# CITY OF ALBUQUERQUE

**Re: Retail Center Shell for Felix Rabadi,  
3500 Menaul Blvd,  
Traffic Circulation Layout Revised  
Architect's Stamp date Revised 1/7/14 (H16-D146)**

Based upon the information provided in your submittal received 1-7-14, the above referenced plan cannot be approved for Building Permit until the following comments are addressed:

New SDMK + RAMP
ADA COMPLIANCE

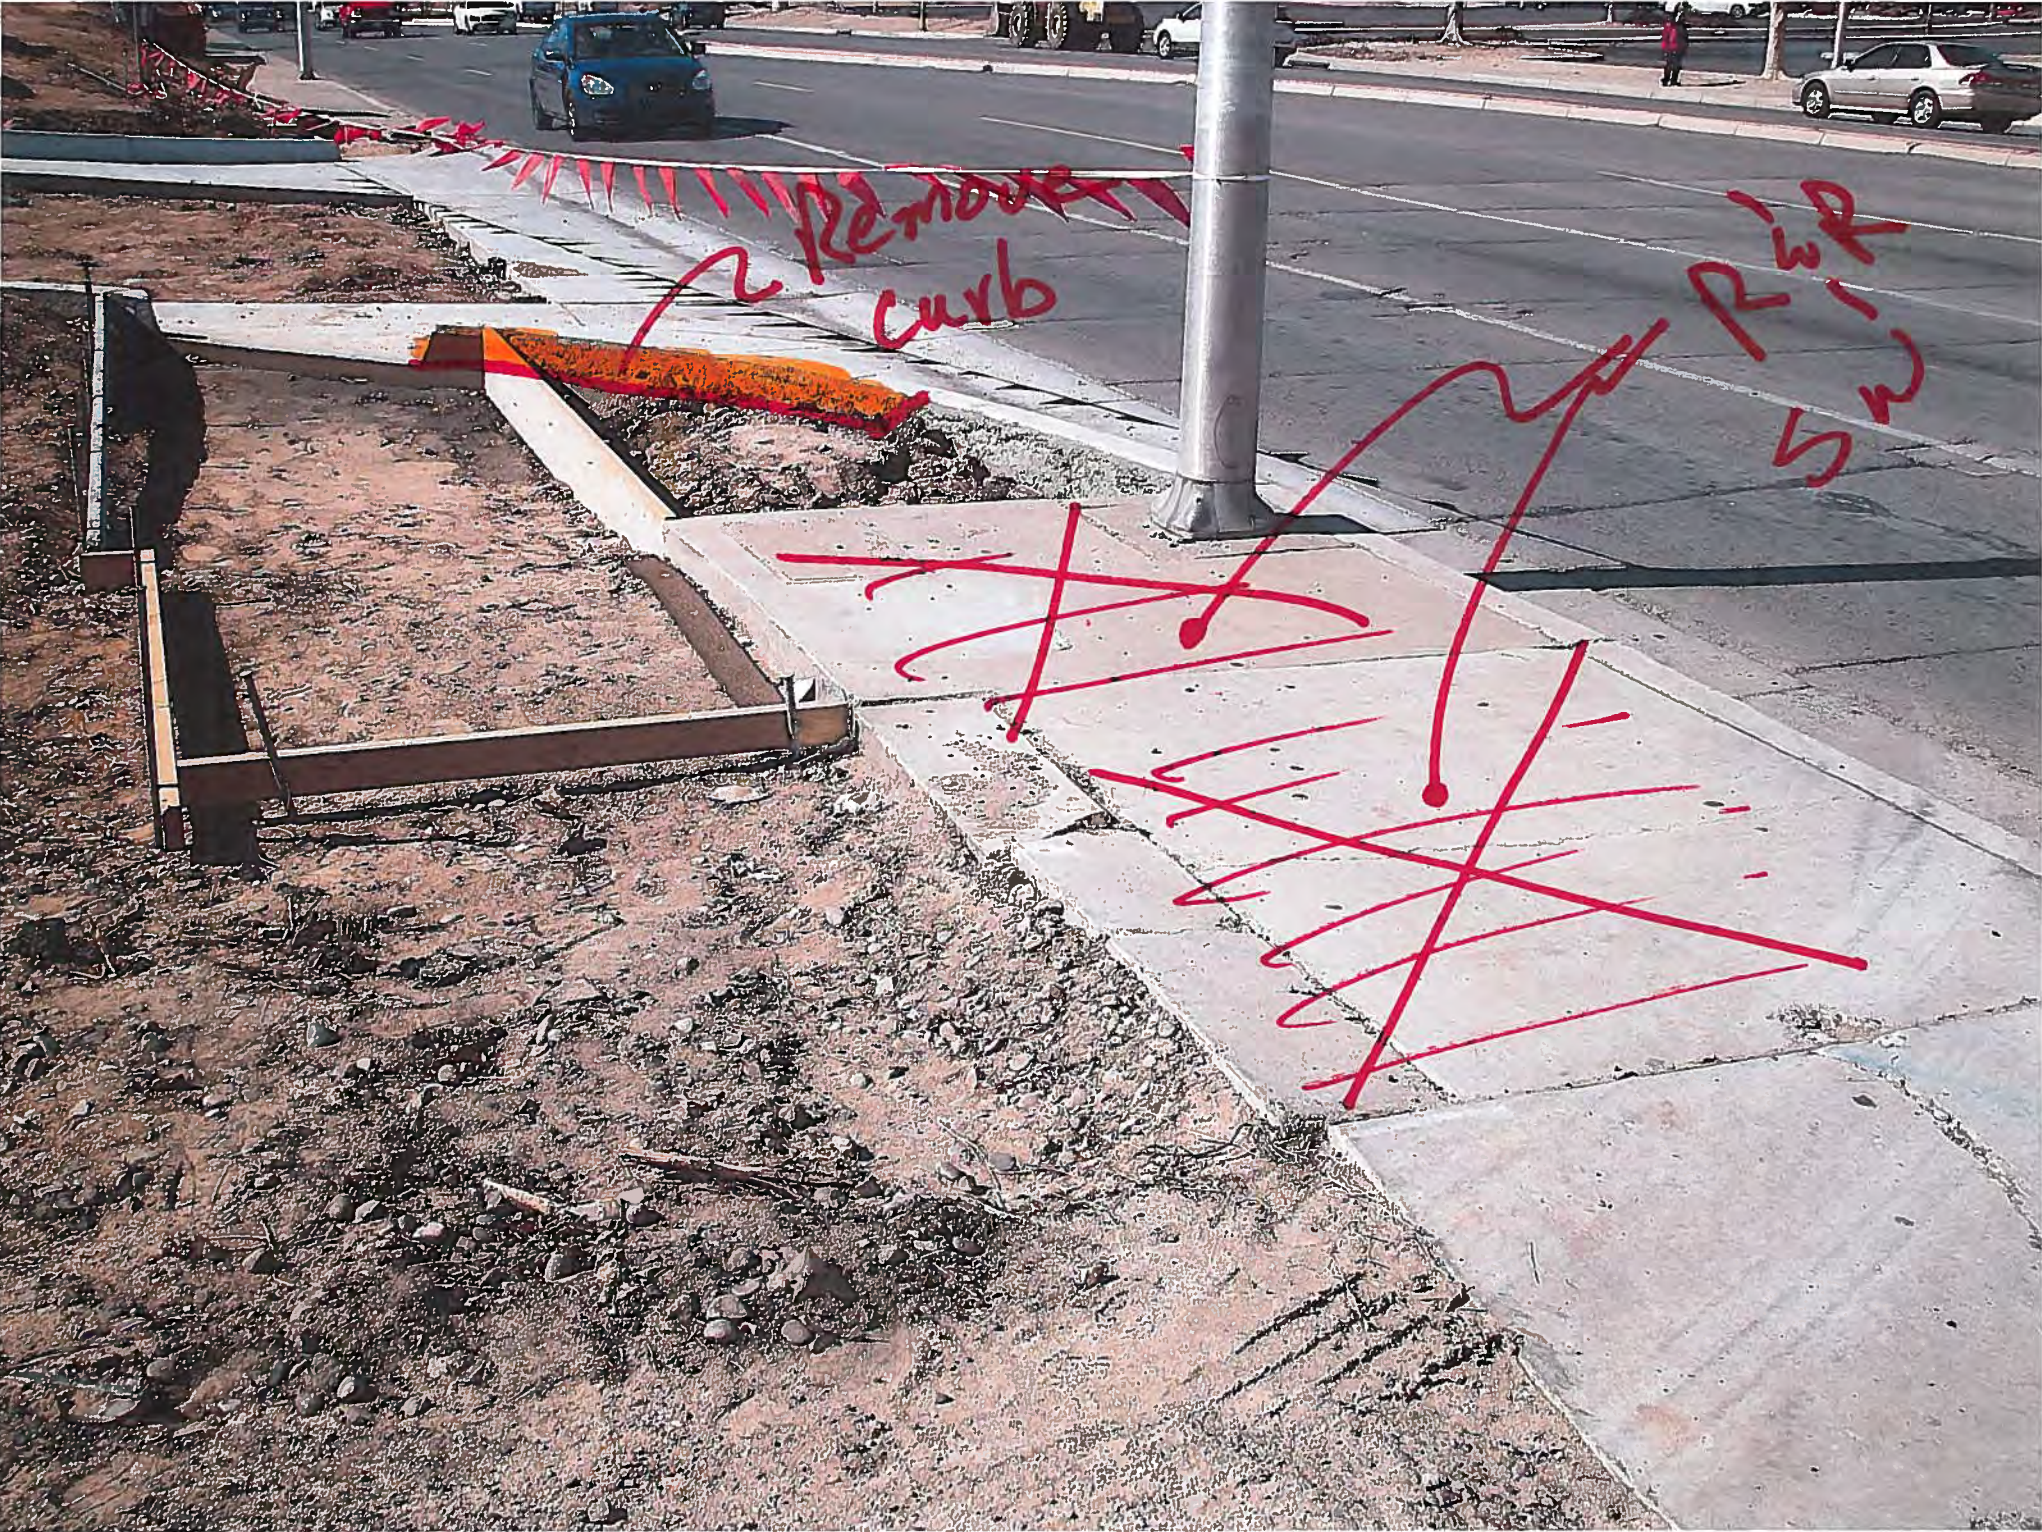
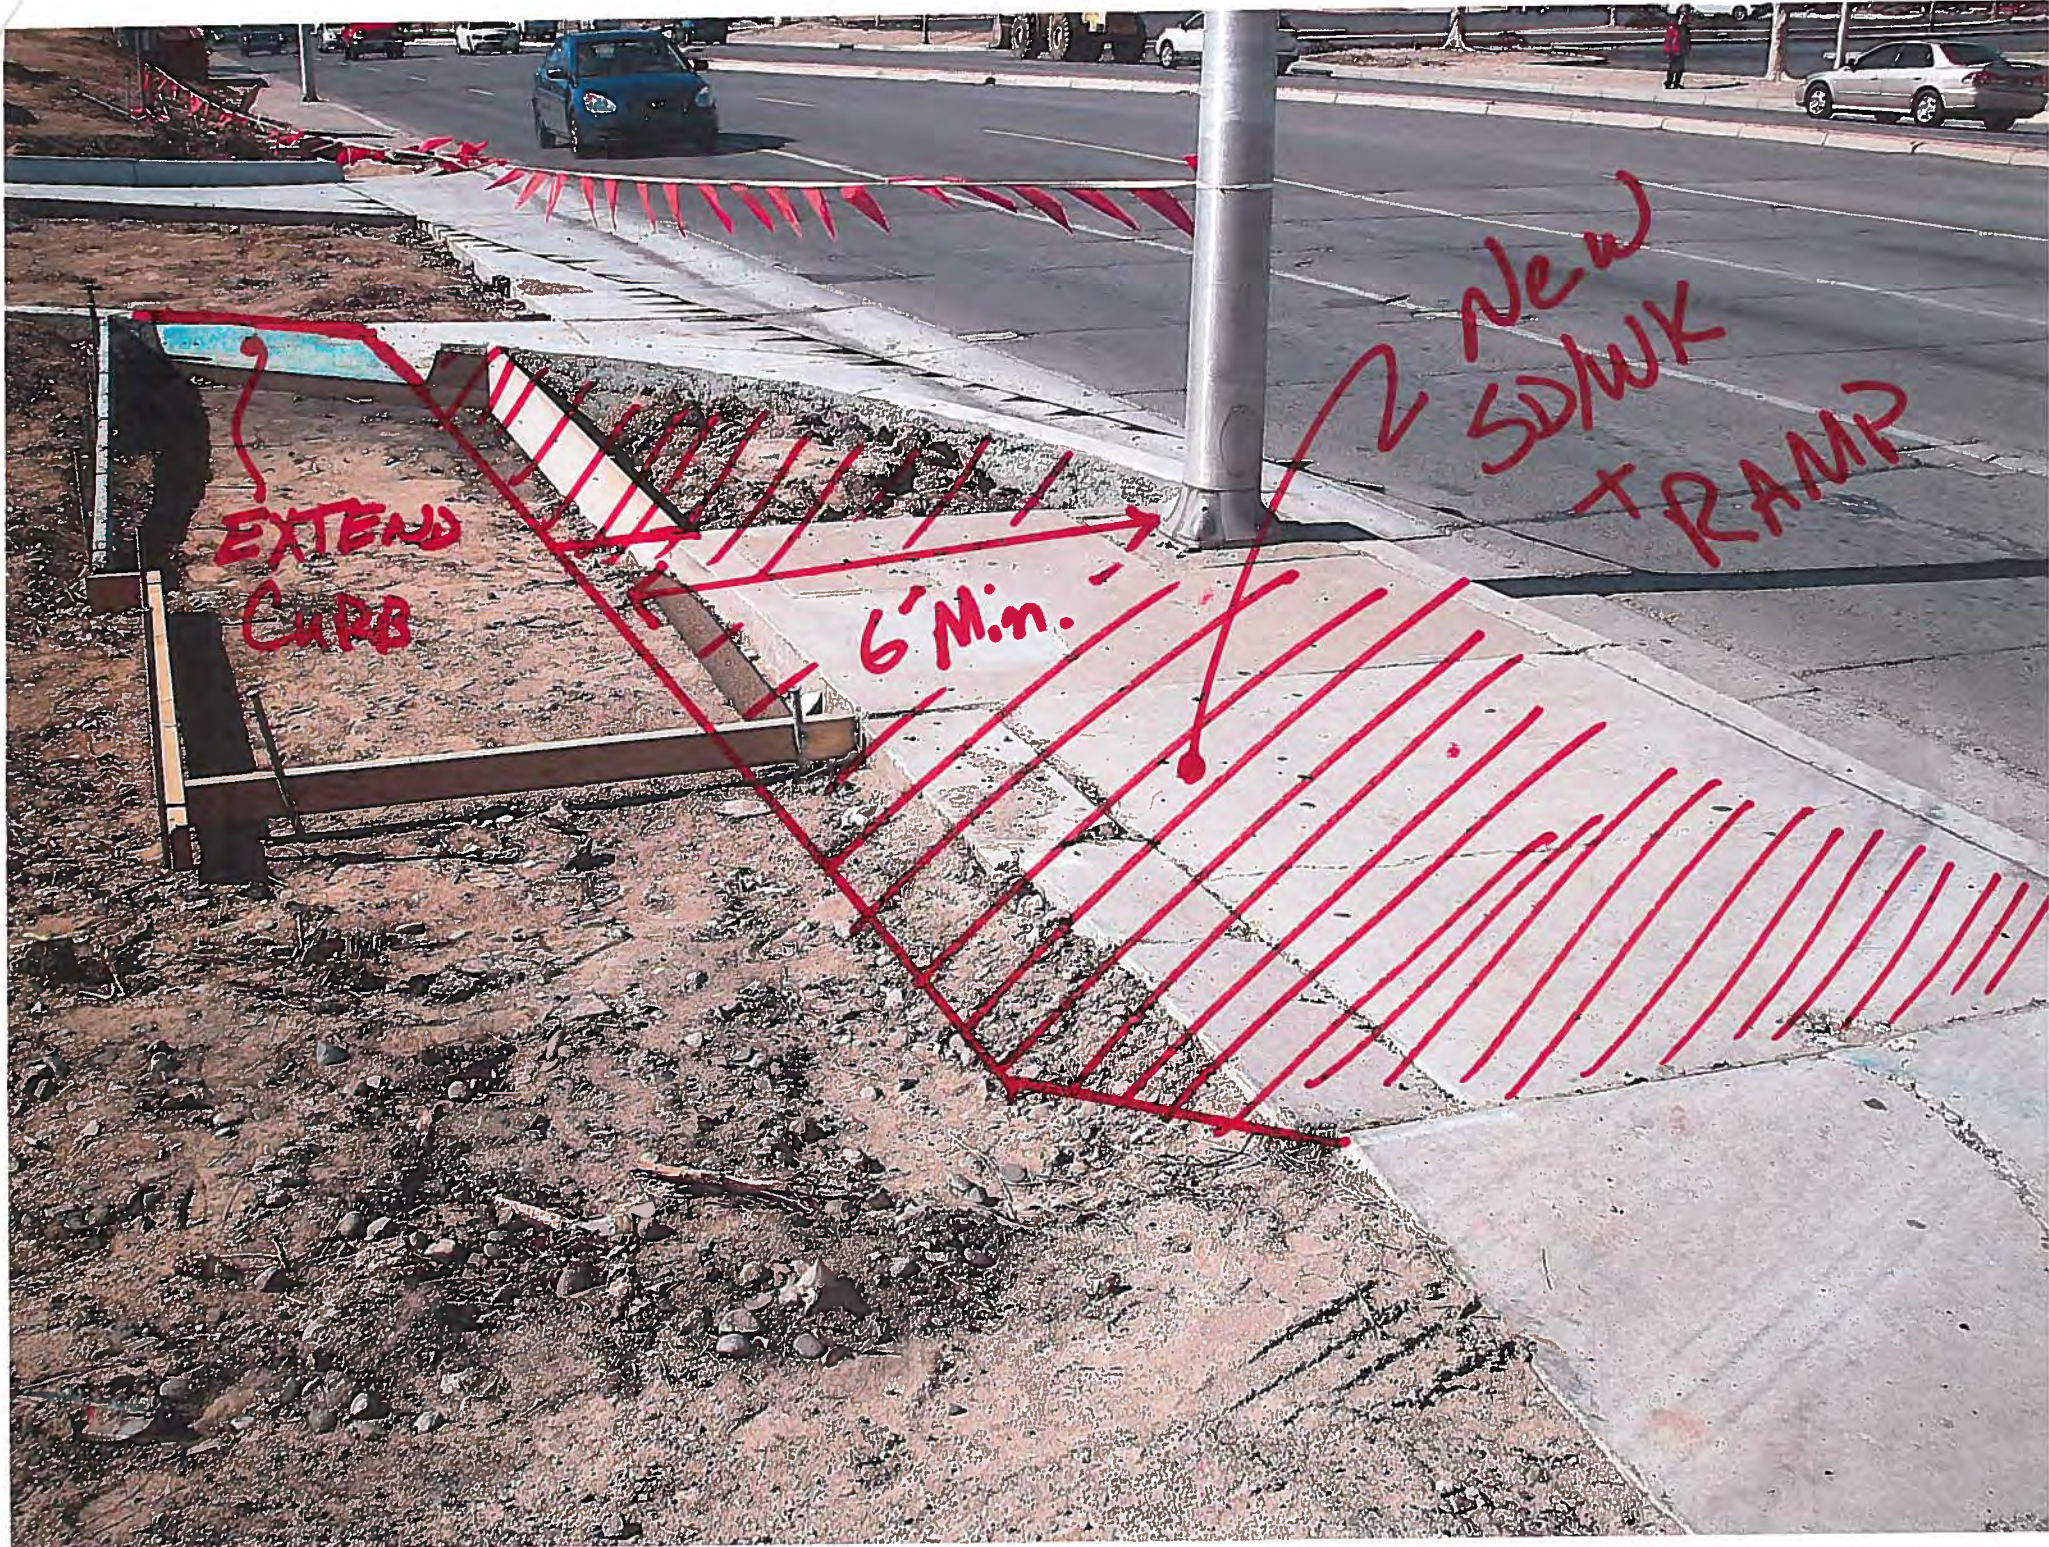
1. Proposed range of 15' – 25' for the curb radius at egress is not acceptable. The radius must be a minimum of 20 ft.
2. The proposed sidewalk easement of 3 feet must be a minimum of 4 ft.
3. The proposed ADA sidewalk ramps of 44" min. must provide 48" minimum width.
